Our ref: Moss Vale Plastics Recycling Facility (SSD-9409987)

17 March 2023

Subject: Request for Additional Information

Figure 7 Revised key haulage route

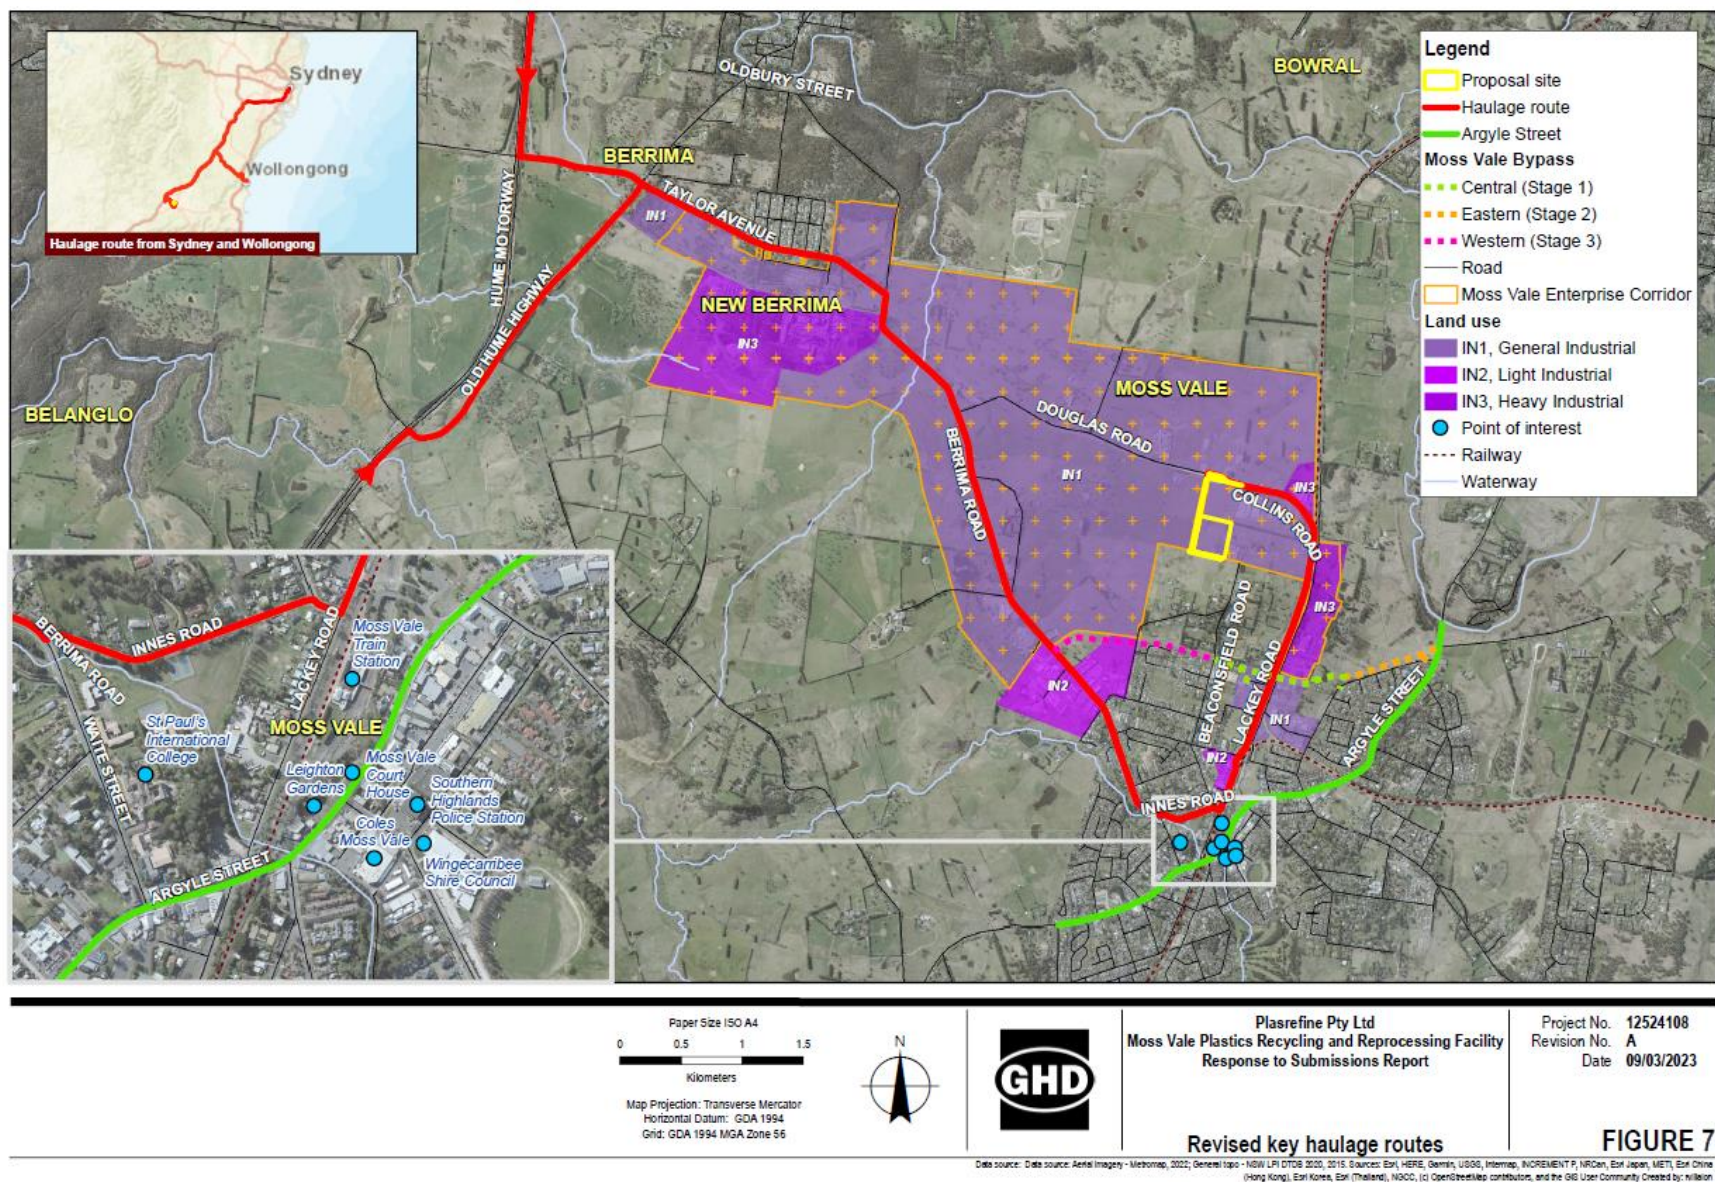
1. The department notes the Waite Street/Lackey Road haul route is currently not designated as a heavy vehicle route. Please provide robust justification for use of this route and the outcomes of discussions with Council about its use for the development.
2. Both Innes Road and Waite Street are adjacent to schools. Please provide an assessment which considers the impact of trucks on the safety of school students, especially during school pick-up and drop-off times.
